RE: Grading and Drainage Plan For 234 Wisconsin (K19-D129) Dated November 5, 2002

Re: TCL Submittal for Building Permit Approval for 234 Wisconsin NE
[K-19 / D129]
Stamp Dated December 10, 2002

Re: TCL Submittal for Building Permit Approval for 234 Wisconsin NE
[K-19 / D129]
Stamp Dated 11/07/02

TRAFFIC CIRCULATION LAYOUT
234 WISCONSIN STREET, N. E.
LOT A, BLOCK 9, MESA VERDE
FOR: LRS CONSTRUCTION

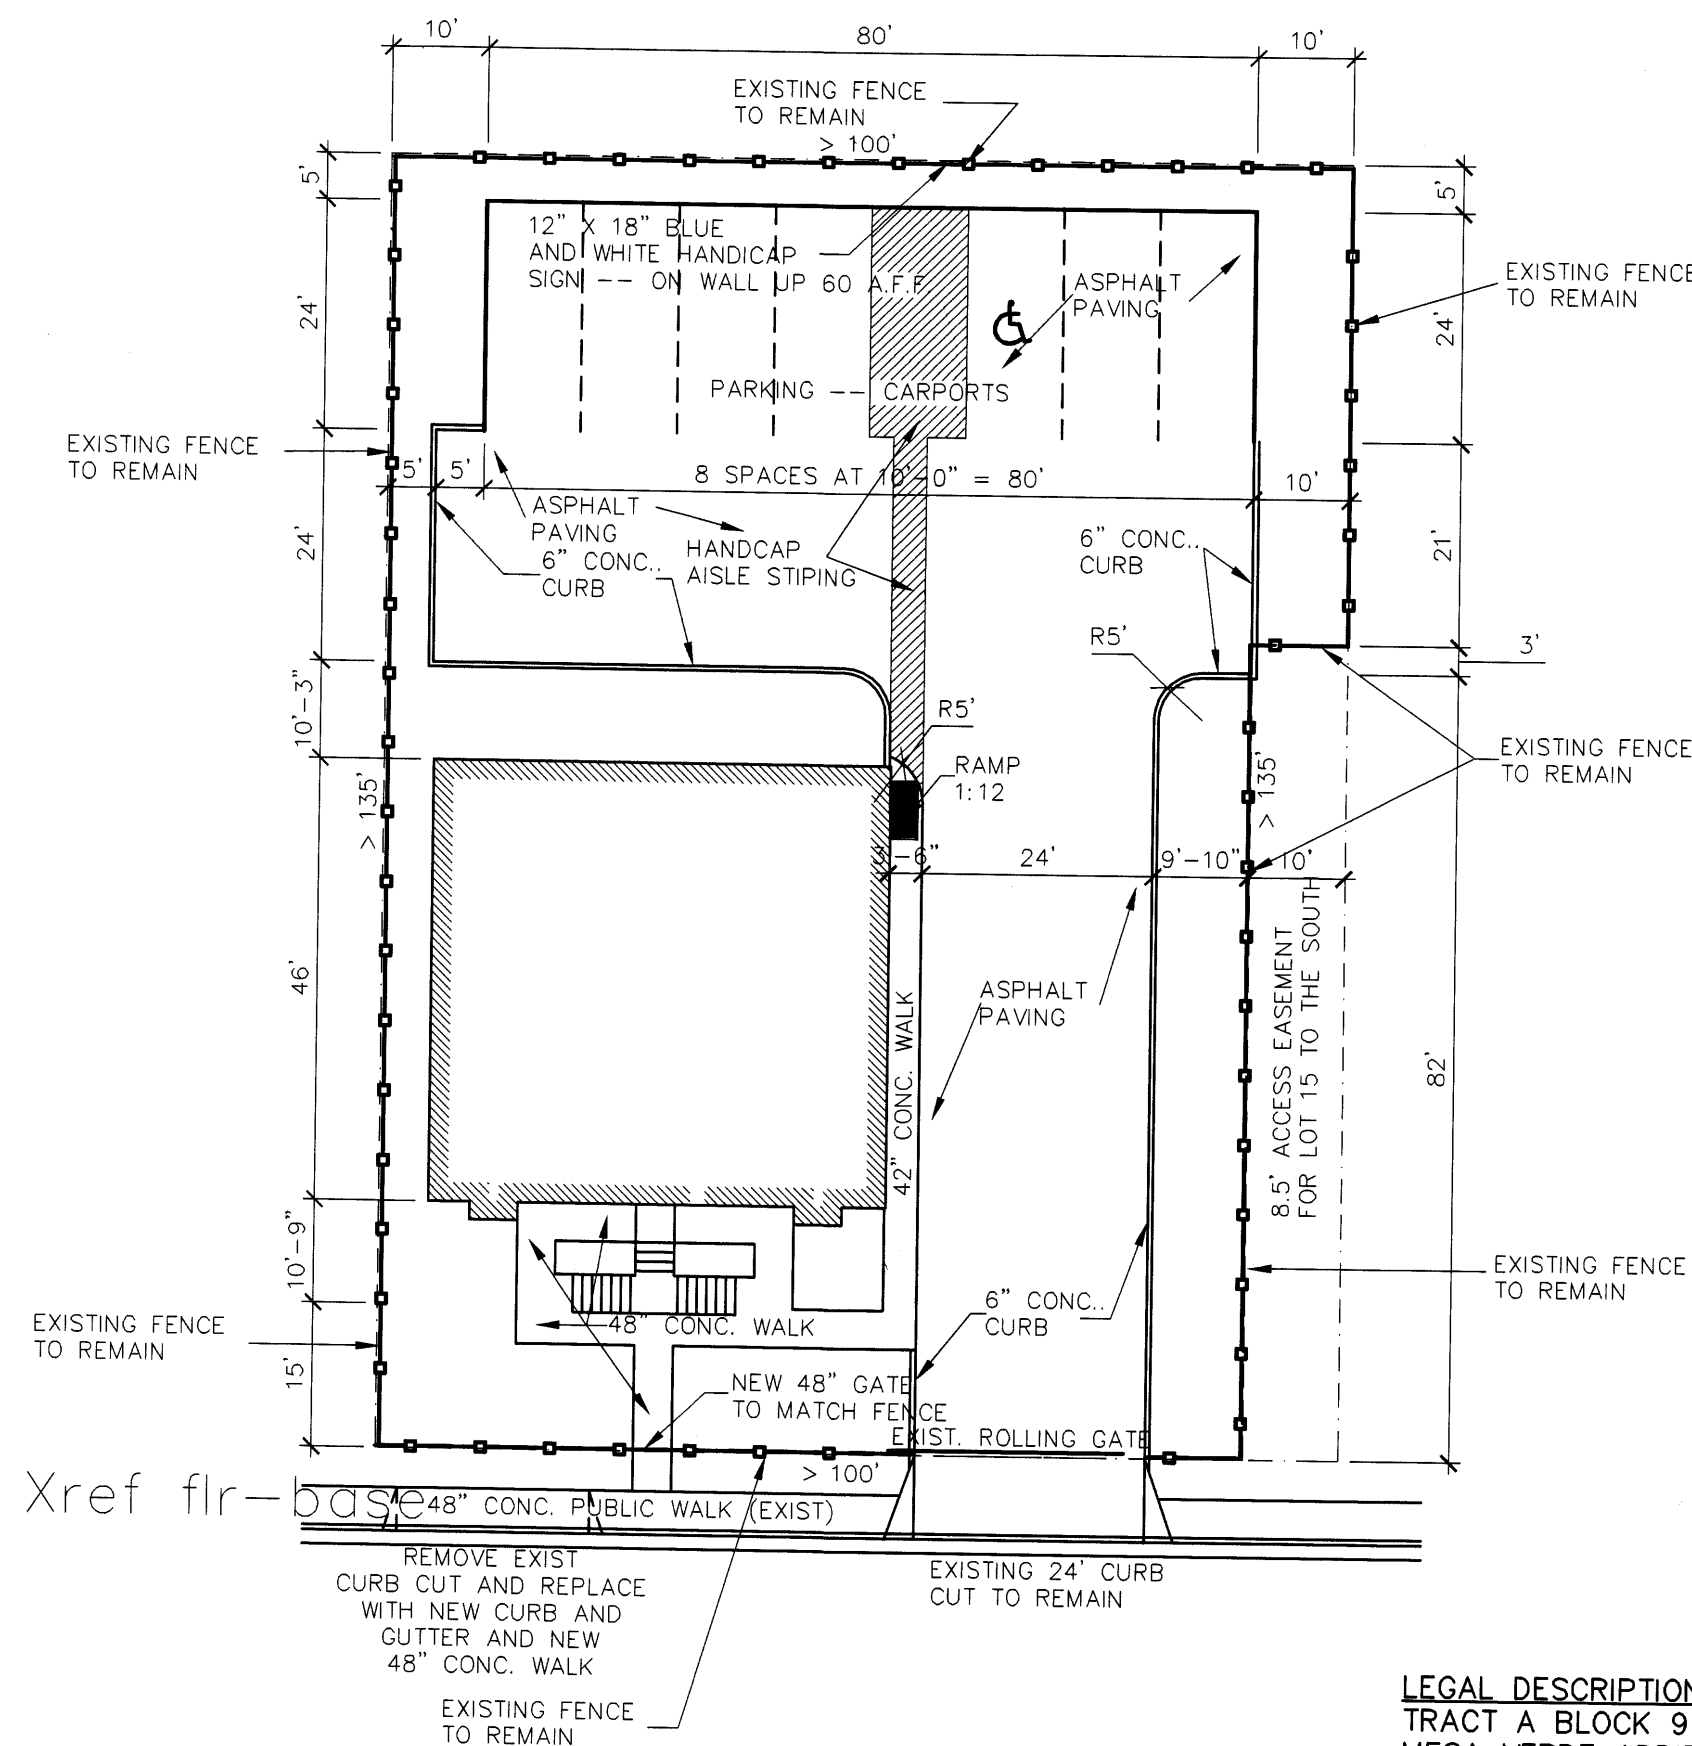
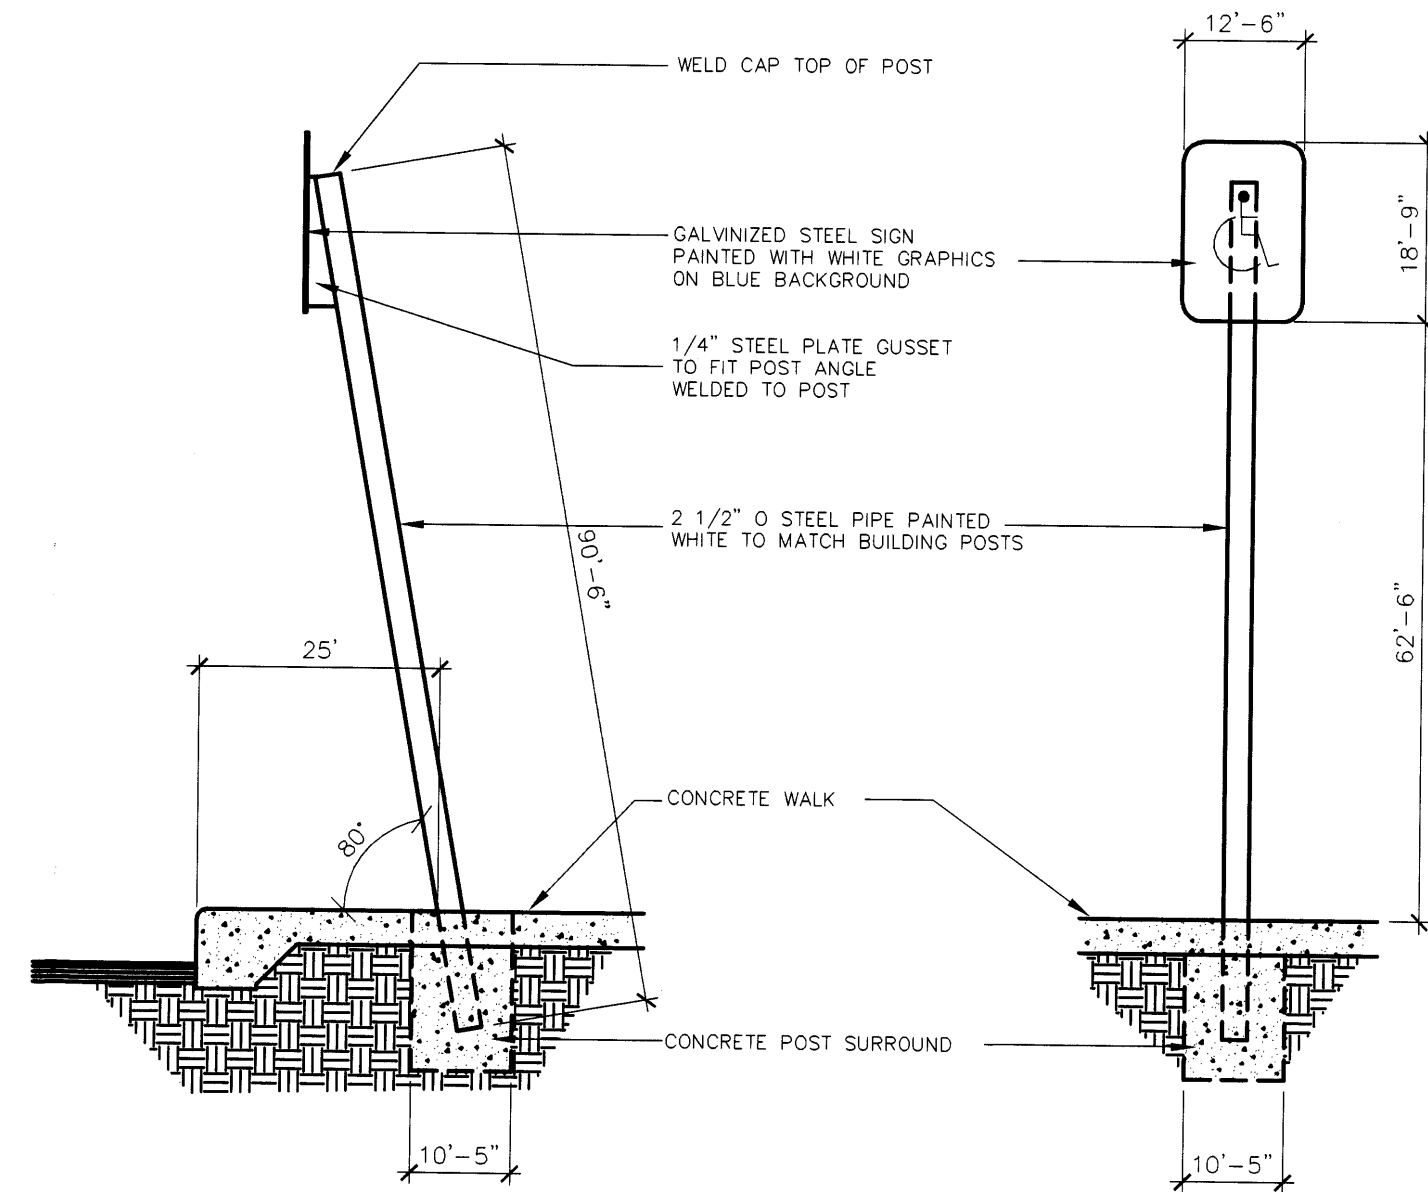
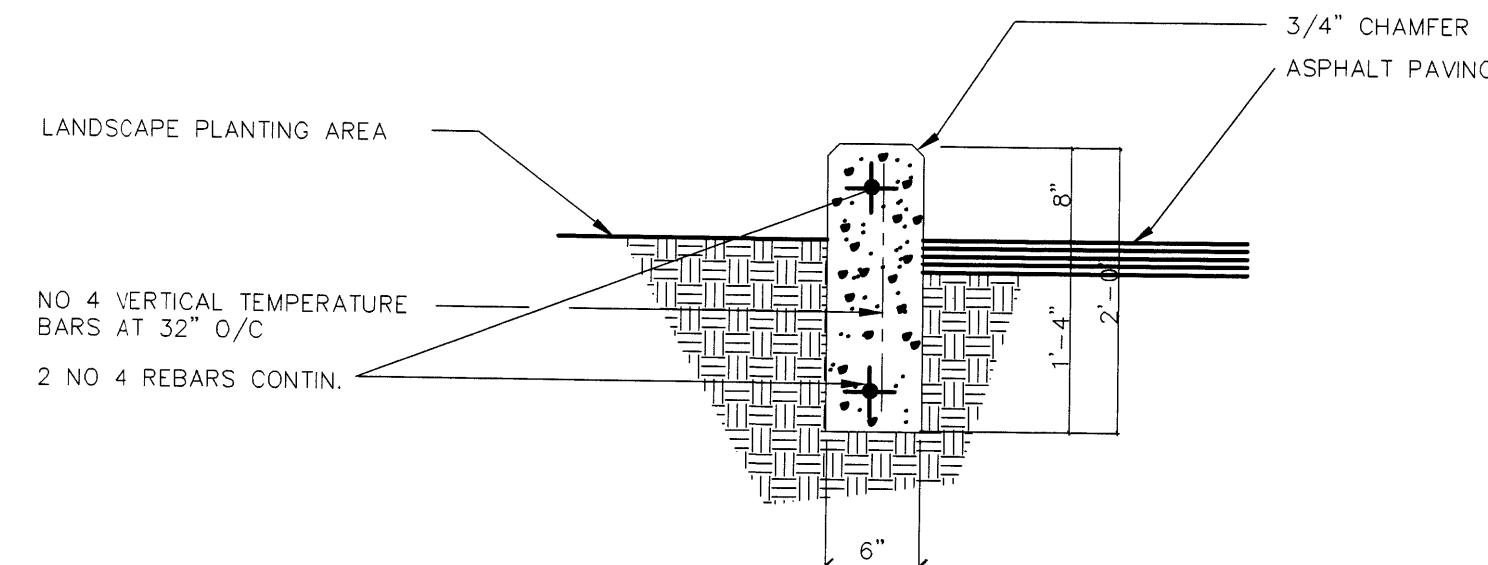
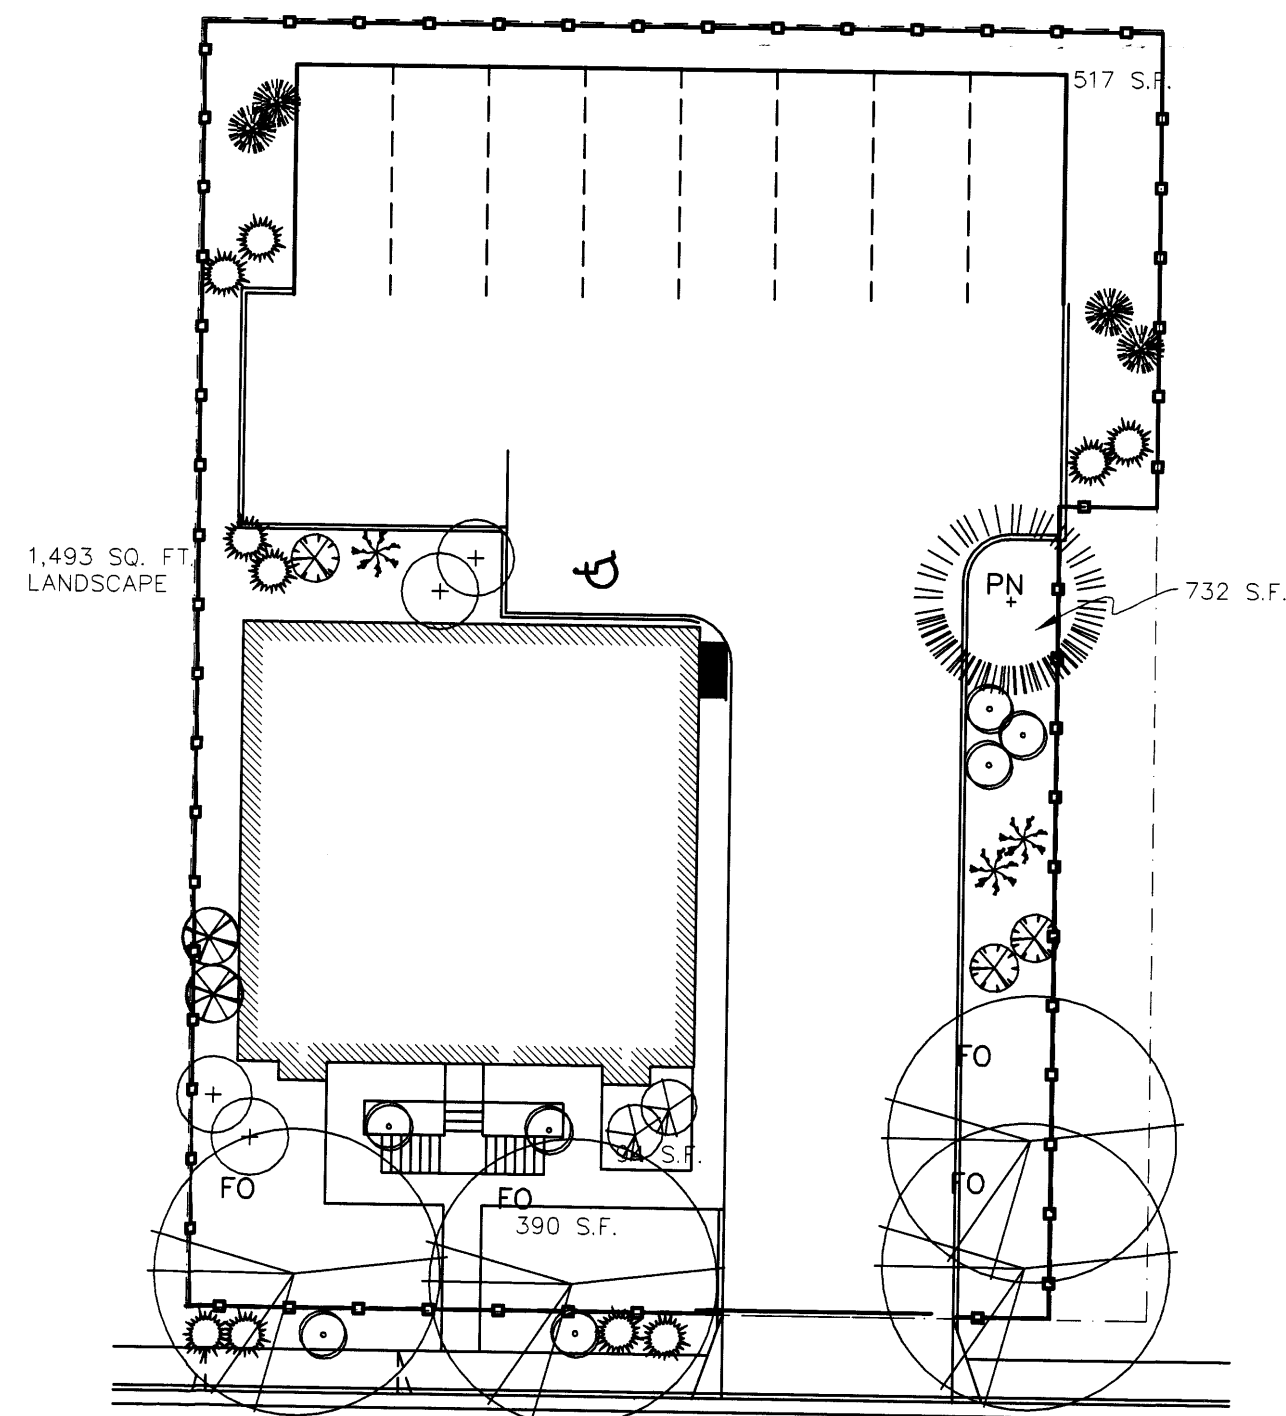
The location referenced above, dated November 11, 2002, is not acceptable and requires modification to the Traffic Circulation Layout (TCL) prior to Building Permit release as stated below.

1. Please move the handicap stall outside of the driving lane.

Please resubmit revised TCL after addressing **this** comment.
